WEST SUSSEX COUNTY COUNCIL CONSULTATION

TO:	Arun District Council FAO:Anita Gardner
FROM:	WSCC - Highways Authority
DATE:	7 May 2019
LOCATION:	The Vinery Arundel Road Arundel BN18 9PY
SUBJECT:	A/48/19/DOC Approval of details reserved by condition imposed under ref A/44/18/PL relating to Condition No 3 site set up and No 6 detailed remediation scheme.
DATE OF SITE VISIT:	
RECOMMENDATION:	No Objection / More Information
S106 CONTRIBUTION TOTAL:	N/A

drawing No: **17029-A-PL24** revision: **A**

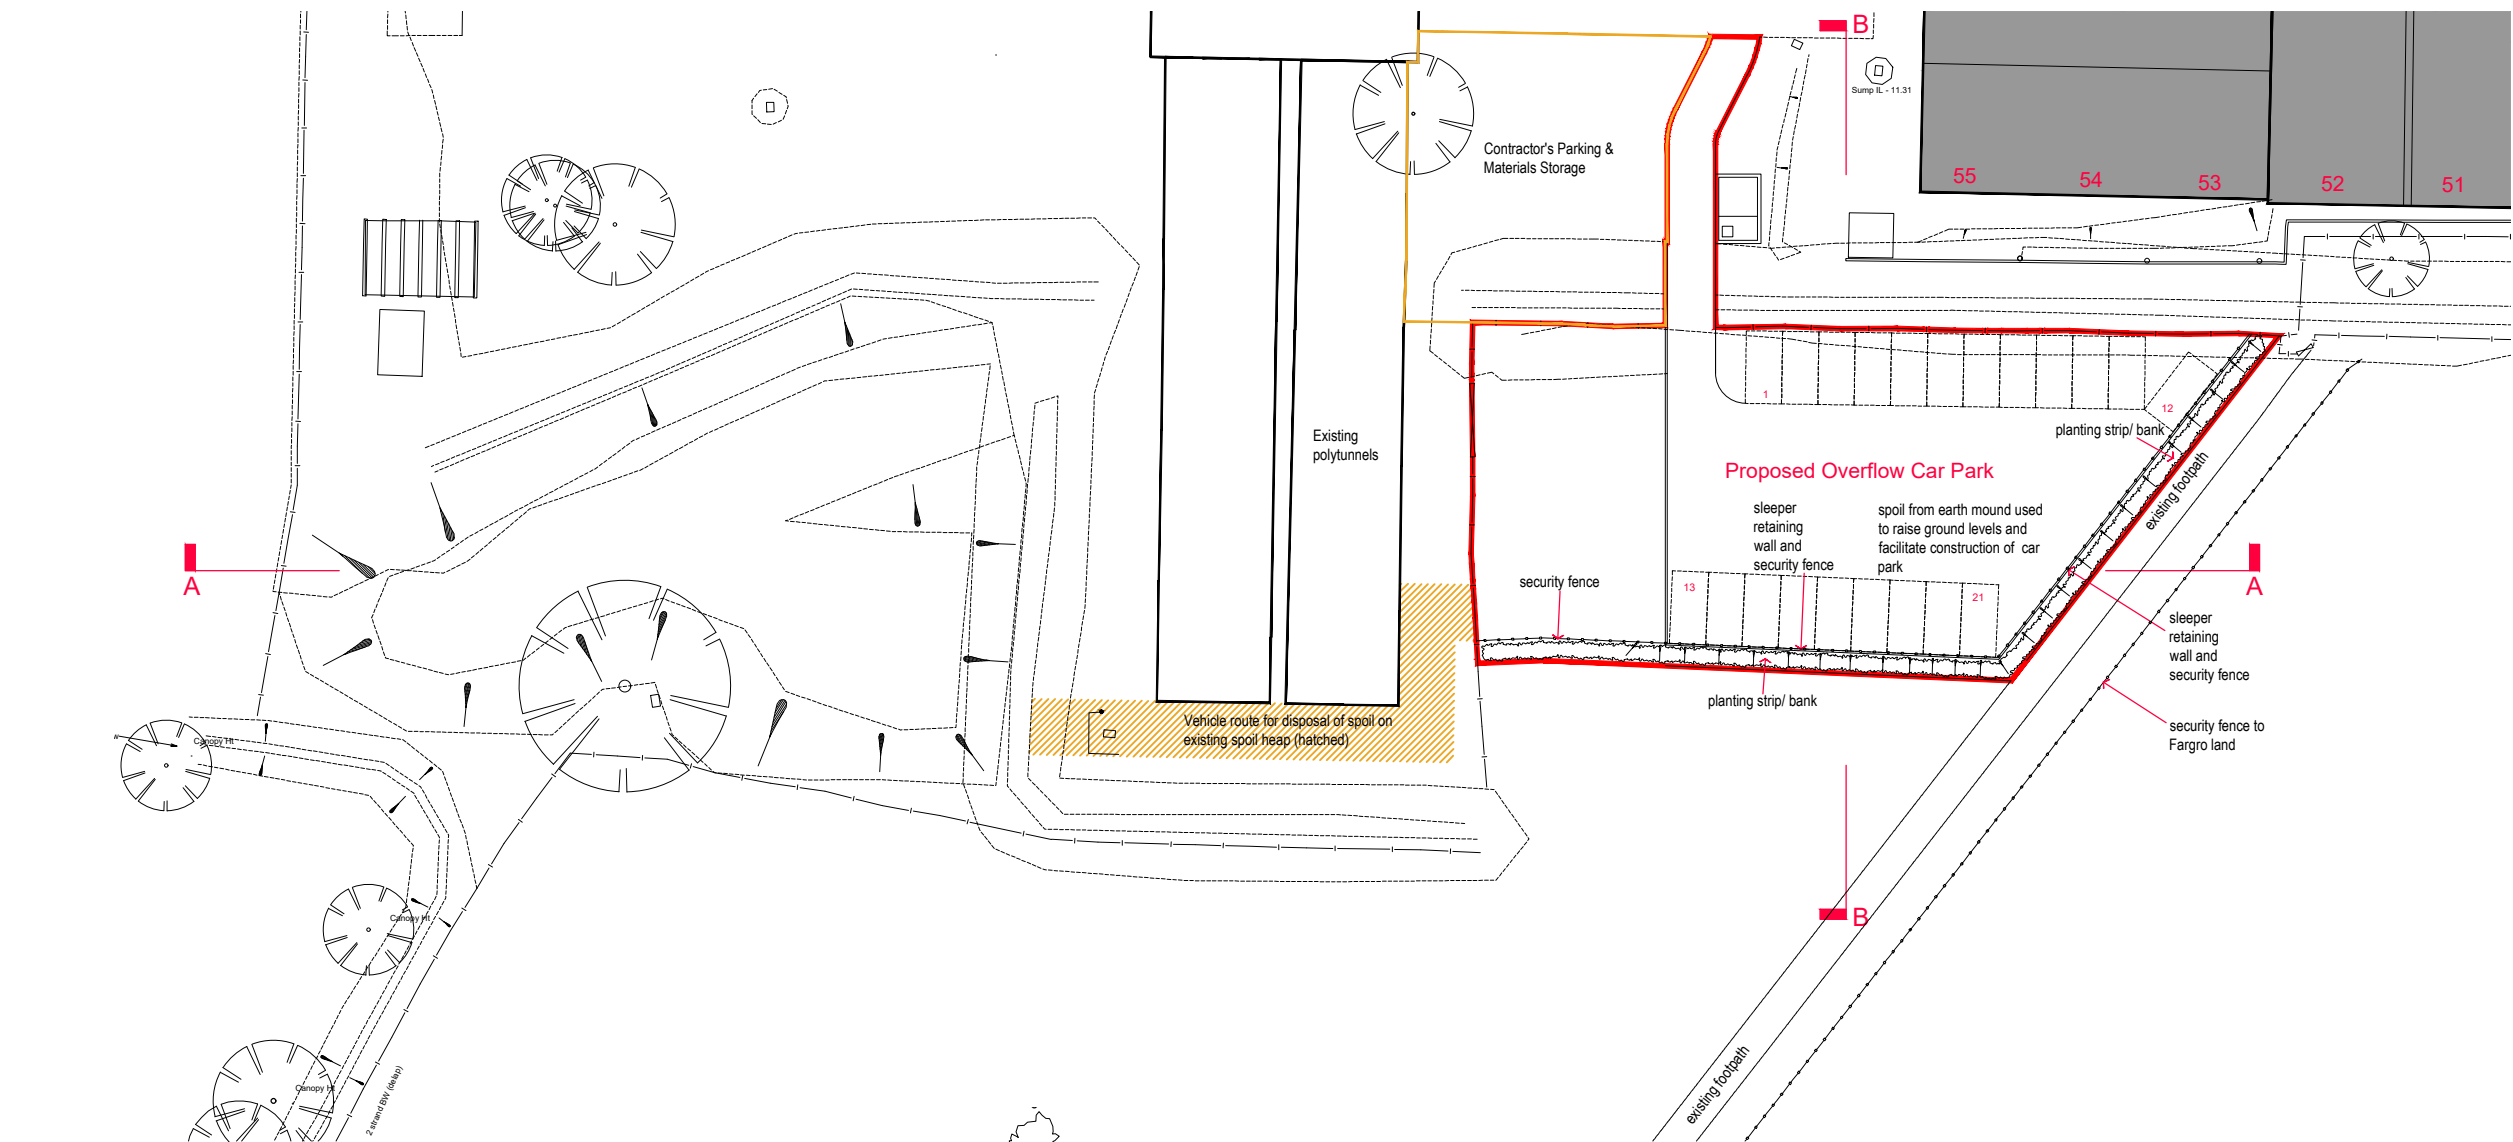
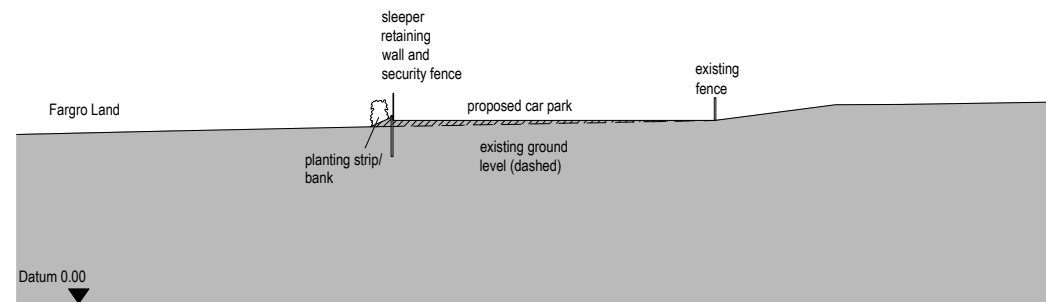
The highway Authority have no objection to the use of machinery as it is existing on site (used for maintenance). No contractor parking is proposed as only 2-3 workers will be employed and therefore existing parking can be used. The Site Management Plan shows Contractor Parking and Material Storage.

Footpath (ANG/2200/2) runs adjacent to the works site - this path will need to be protected and open during the works. In addition, works should not impact on the integrity of the footpath. Please request the applicant contact our PROW officer for their approval - the officer has been copied in on this response.
